Subject: Re: Questions about the Sensitive Lands Analysis for the Major Preliminary Plat for PR-2025-020092, MAJOR_PLT-2025-00016
Date: Tuesday, December 16, 2025 4:51:35 PM
Attachments: [Discrete Slope Measurements.pdf](#)
[Screenshot 2025-12-04 at 4.38.19 PM.png](#)
[Screenshot 2025-12-04 at 4.38.20 PM.png](#)

Please see the attached supplemental submittal and message below from WSCONA in response to the supplemental submittal from the agent for the applicant, for item #1, PR-2025-020092, MAJOR_PLT-2025-00016 on the December 17th DHD agenda, a Major Preliminary Plat.

PASEO AND KIMMICK EAST
ALBUQUERQUE, NM
CONCEPTUAL GRADING
AND DRAINAGE PLAN

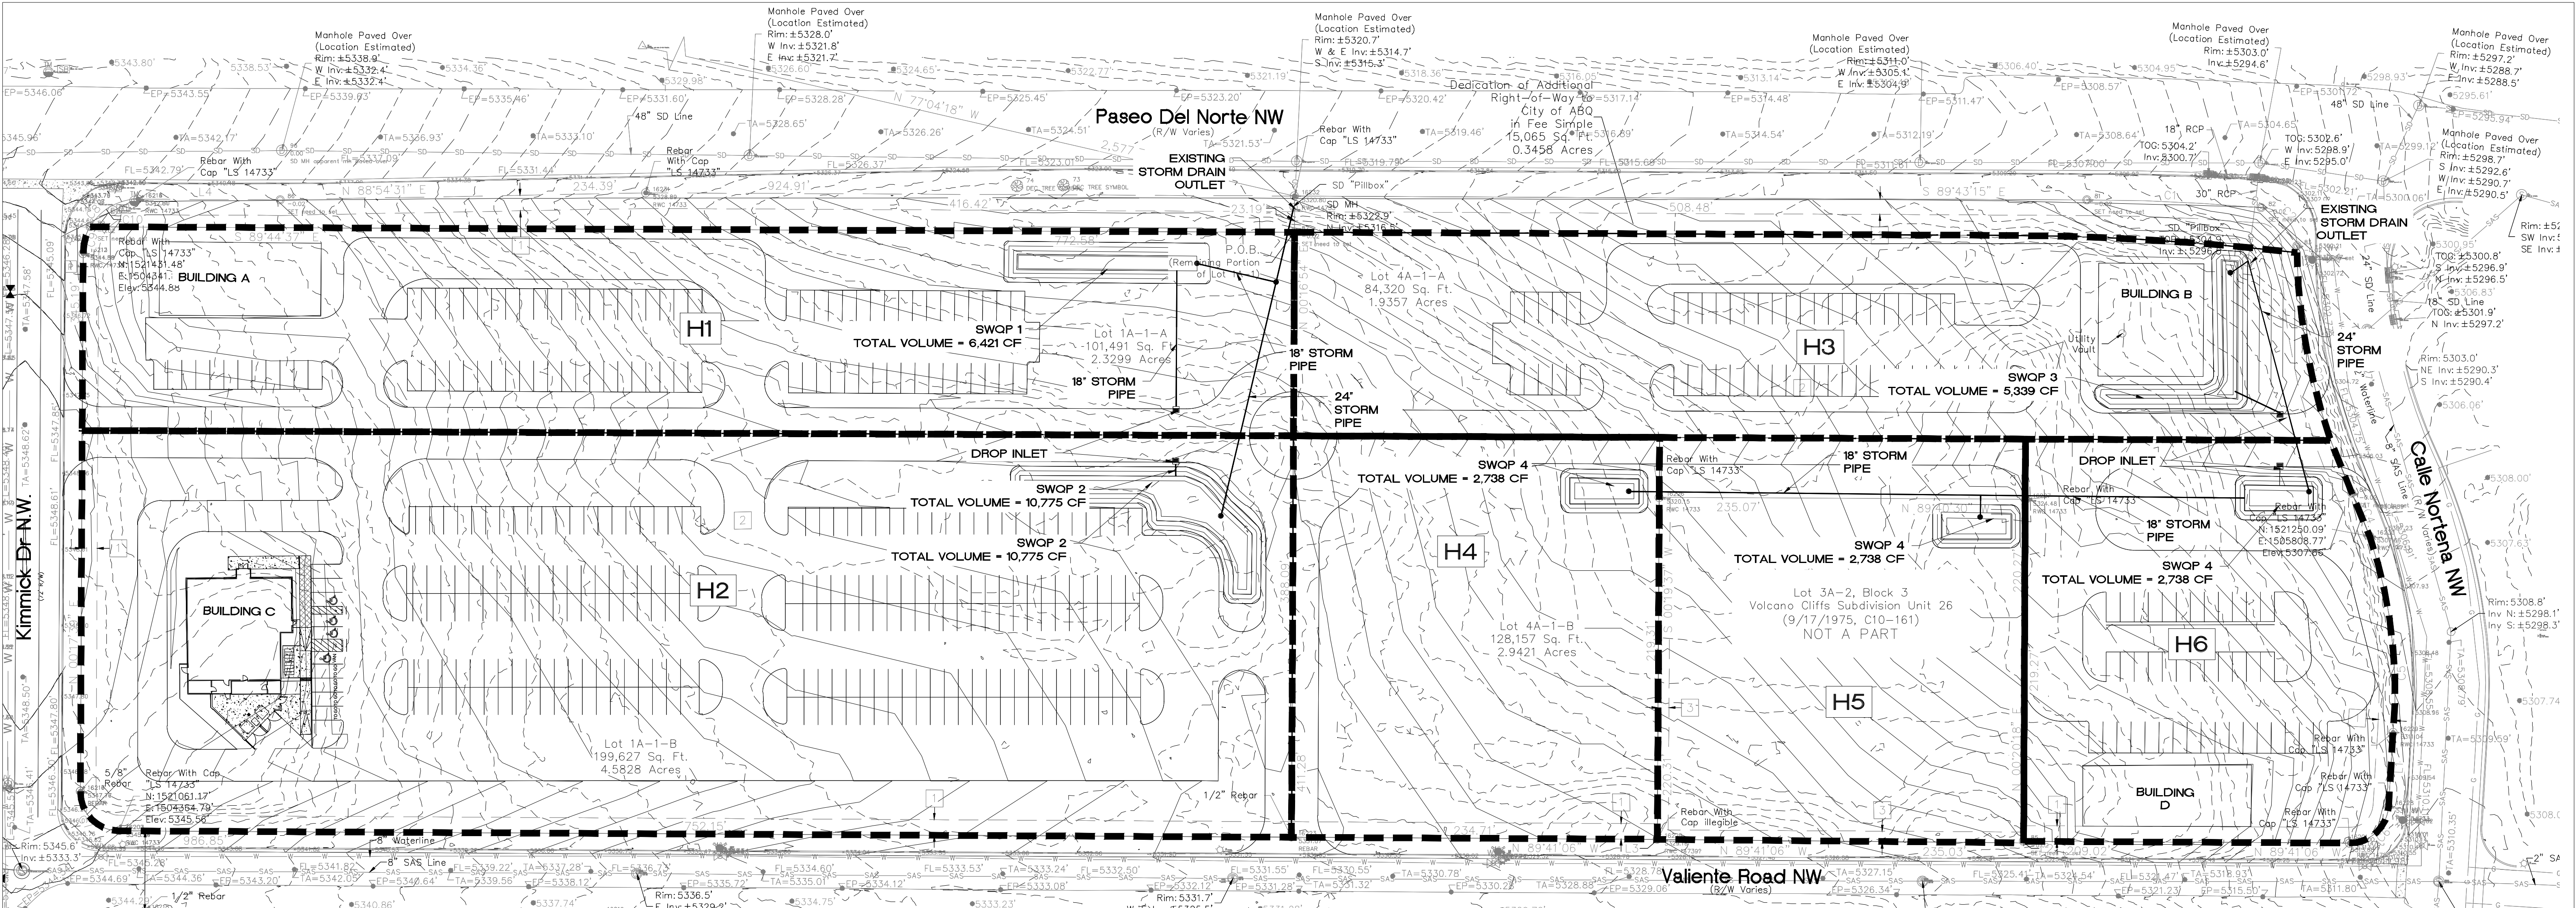
As can be seen using the agent for the applicant's own survey, discrete measurement across both parcels of the site in question have a slope of greater than 9%. This is not surprising in that the property lies just as Paseo del Norte rises through the escarpment.
